Charlotte Storm Water  
600 East Fourth Street  
Charlotte, N C 28202-2844

## *Rezoning Petition Review*

**Date of Review:** July 27, 2020 (***Revised September 25, 2020***)

**Rezoning Petition #:** 20-88

PCR MIXED USE
 PREPARED FOR
WSB RETAIL
 CITY OF CHARLOTTE, NC
 SHEET NUMBER
RZ-1

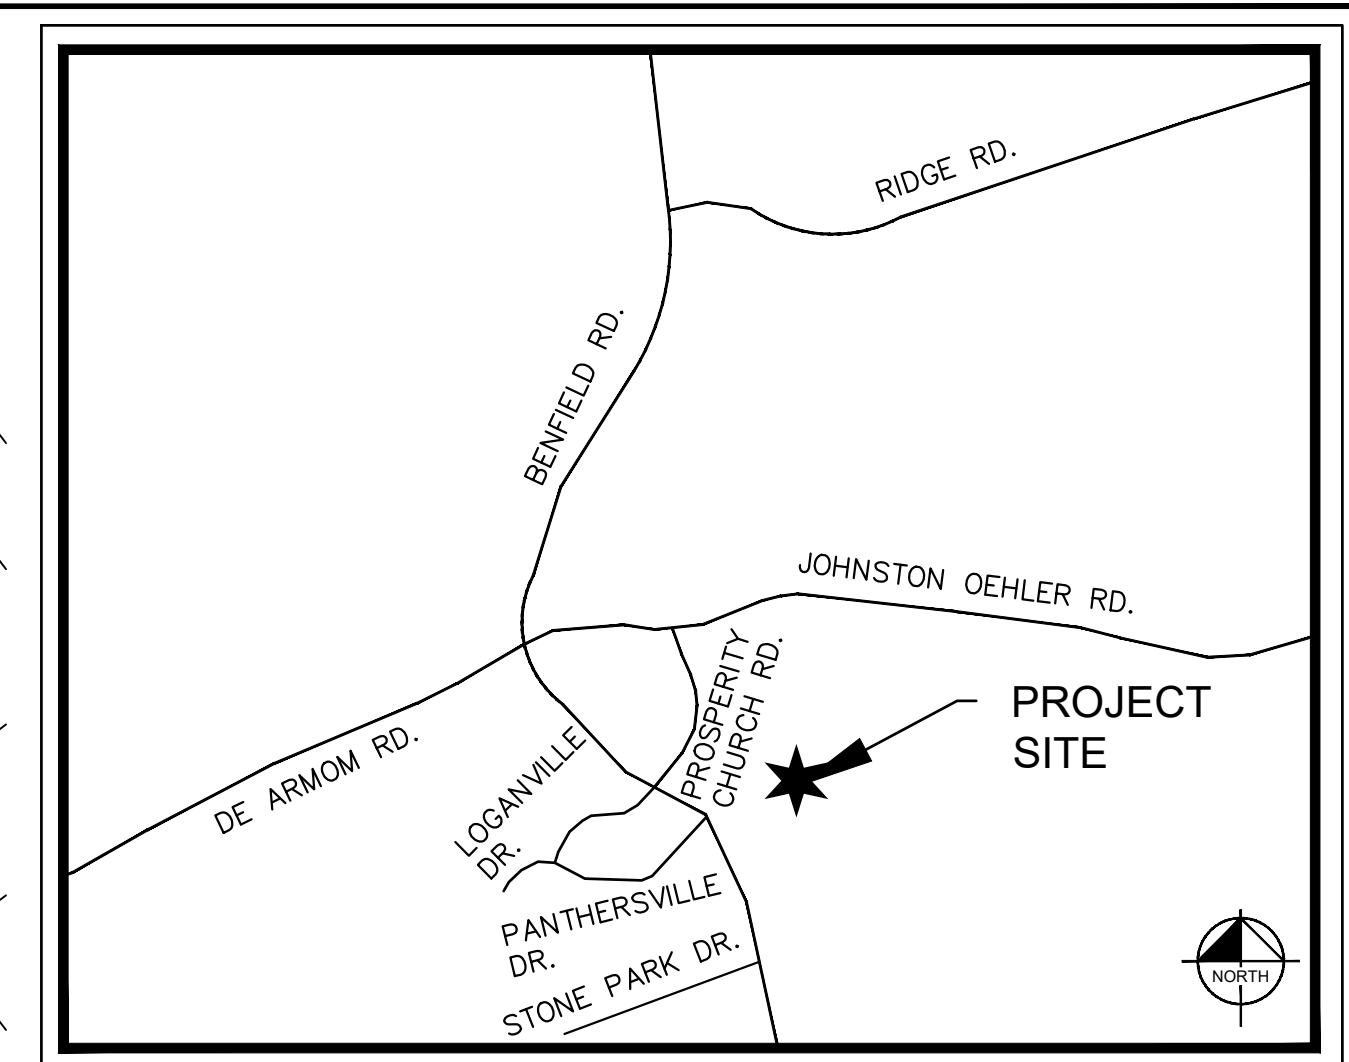
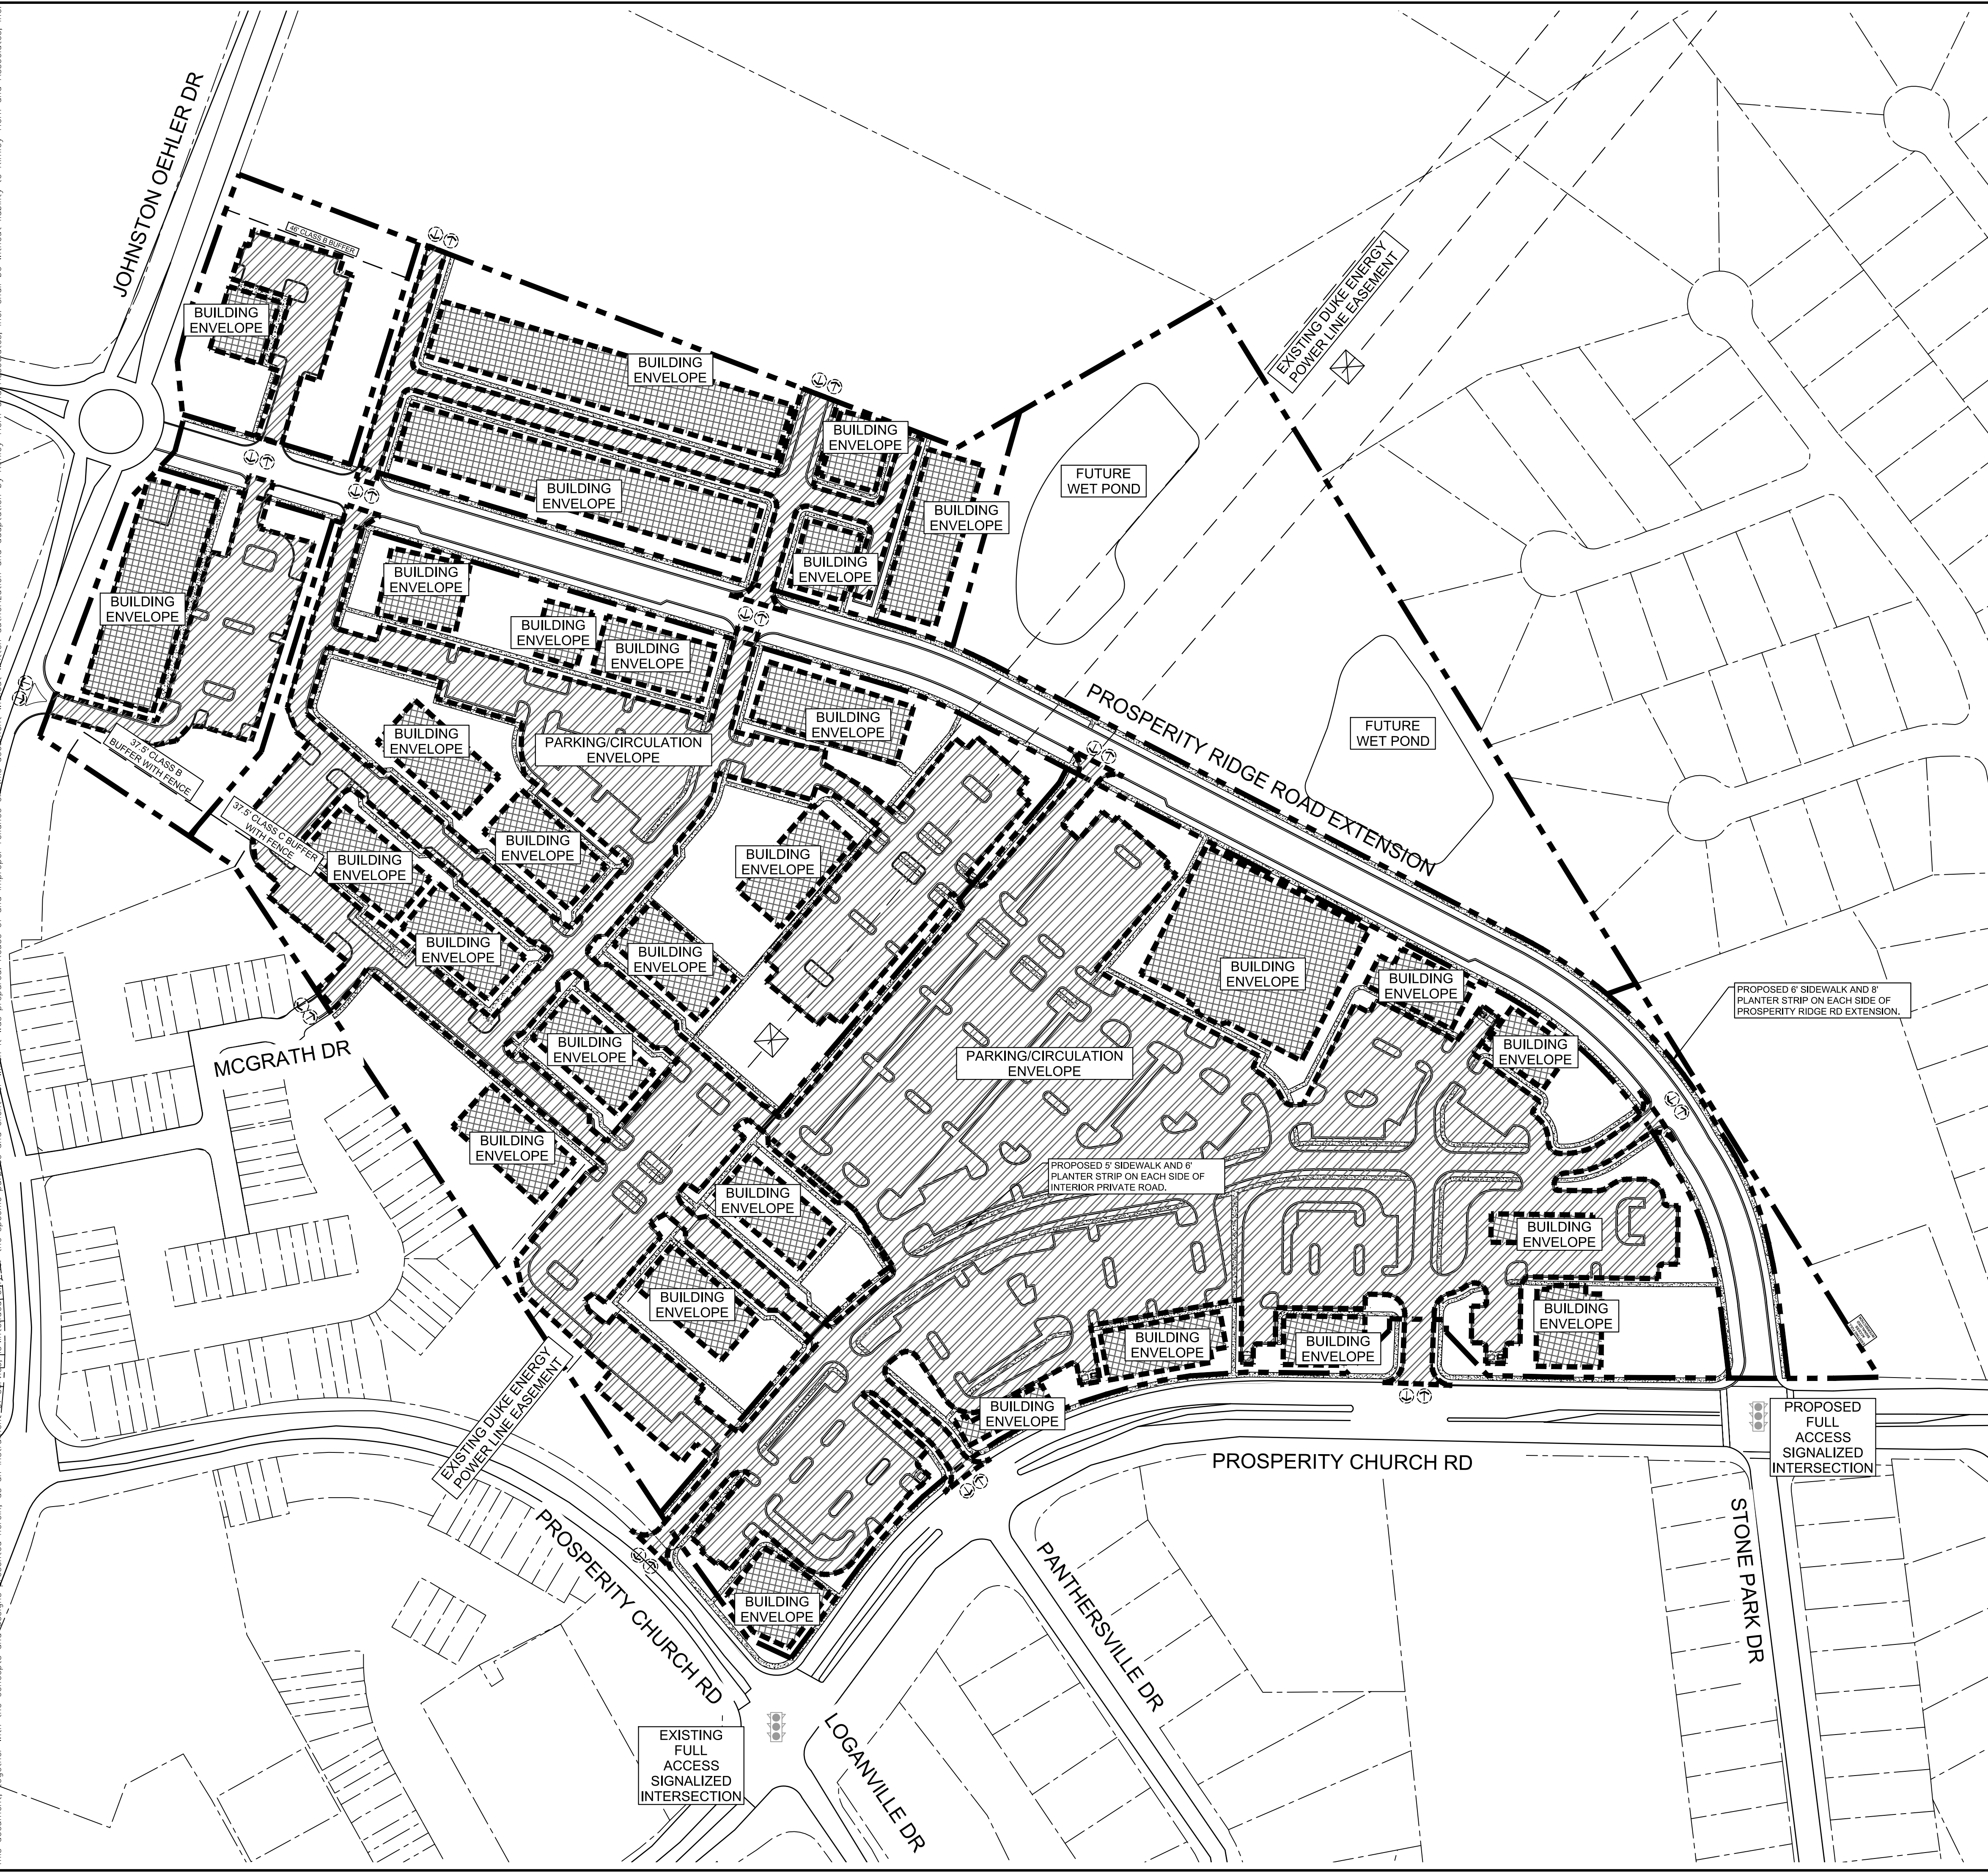
**Concerning Storm Water:** City of Charlotte GIS data indicates a 50-ft Undisturbed PCSO buffer and a 100-ft Undisturbed PCSO buffer across the site. Please show and label these buffers on the site plans. Any increase of impervious area within such buffers may not be allowed and is not approved with the rezoning process. Stream Delineation Reports are subject to review and approval by Charlotte Storm Water Services. Please include the following note under Environmental Features: *“Development within any SWIM/PCSO Buffer shall be coordinated with and subject to approval by Charlotte-Mecklenburg Storm Water Services and mitigated if required by City ordinance.”*

**Due to revisions (9/25/20):** No additional recommendations are needed at this time.
